Application H02-0430-18
Location 2 West Bank Crowland PE6 0HP
Proposal Replacement dwelling - re-submission of H02-1151-17

Name Ian Marshman, Historic Environment Officer
Address Lincolnshire County Council Places Team Lancaster House Orchard
Street LN1 1XX

Date Submitted 25-05-18
For/Against Comments

Elevation 01 – Front
1 : 100

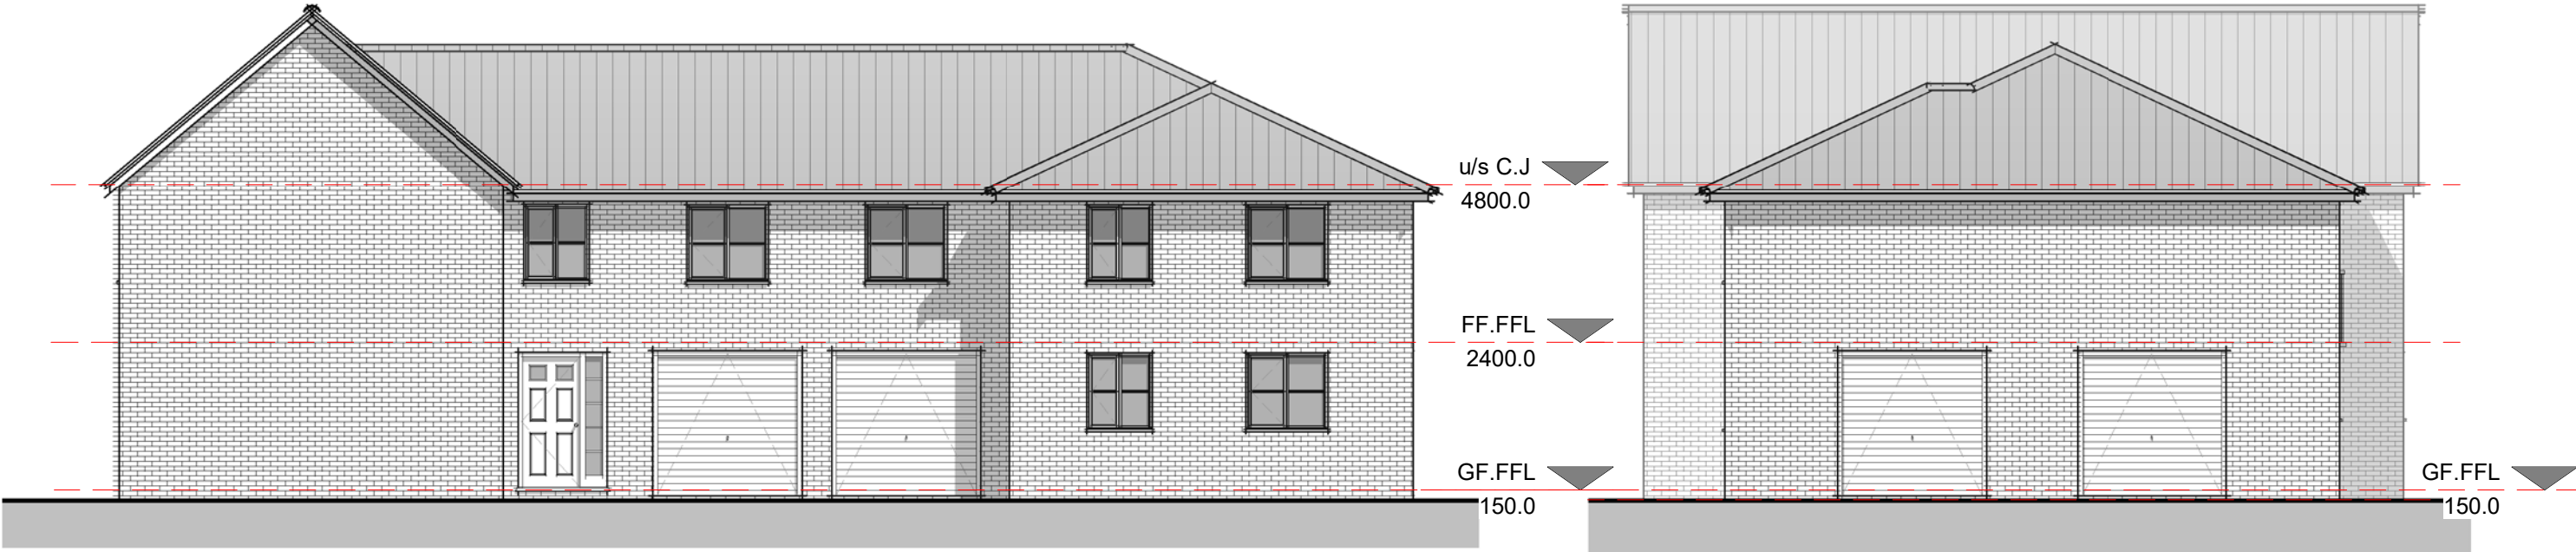
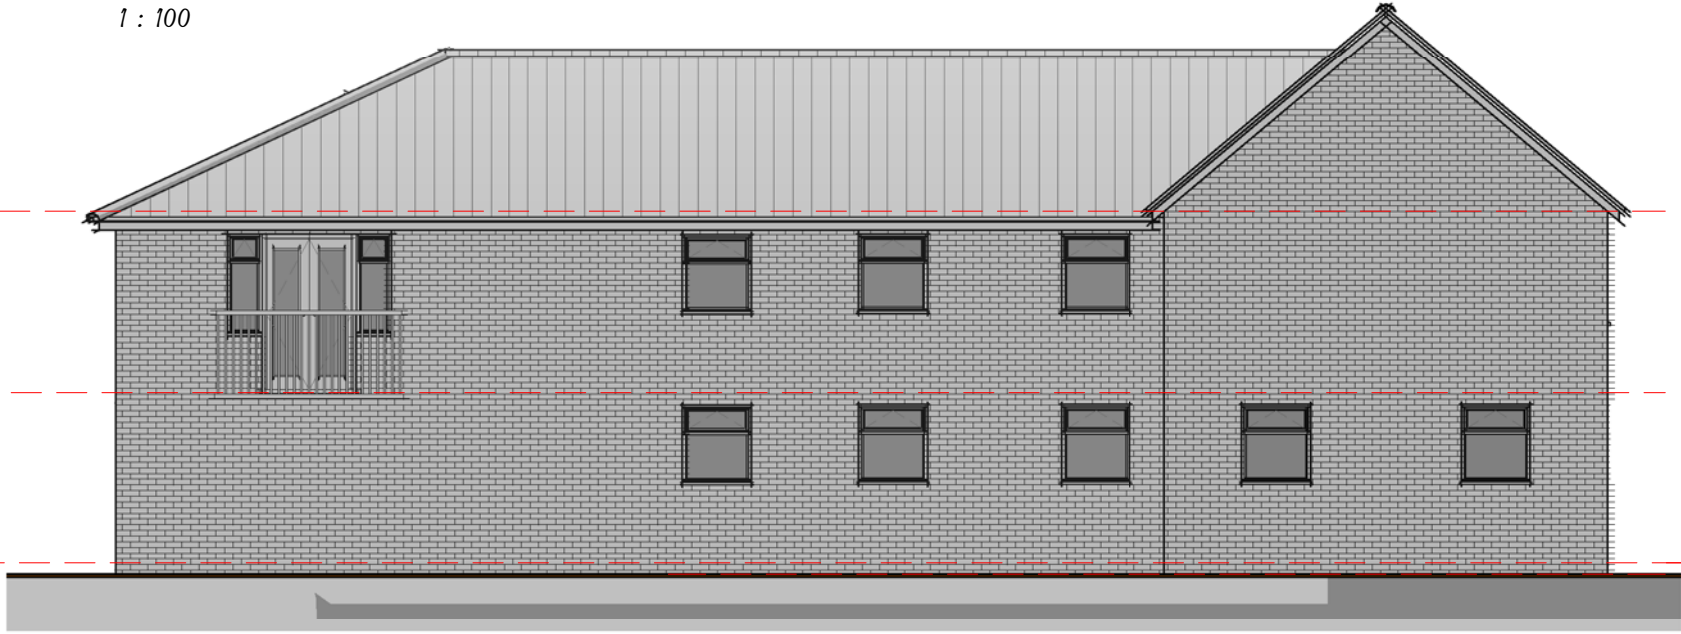
These revised proposals are in the view of this office worse than those previously submitted because of the second storey's greater impact on the town's historic environment.

These include the harm caused by such a large unsympathetic box-like house to the setting of the neighbouring conservation area, and the blocking of views the proposed development could cause. National Planning Policy states that "significance can be harmed or lost through alteration or destruction of the [designated] heritage asset or development within its setting. As heritage assets are irreplaceable, any harm or loss should require clear and convincing justification" (section 12, paragraph 132). The creation of a single dwelling house is not sufficient justification.
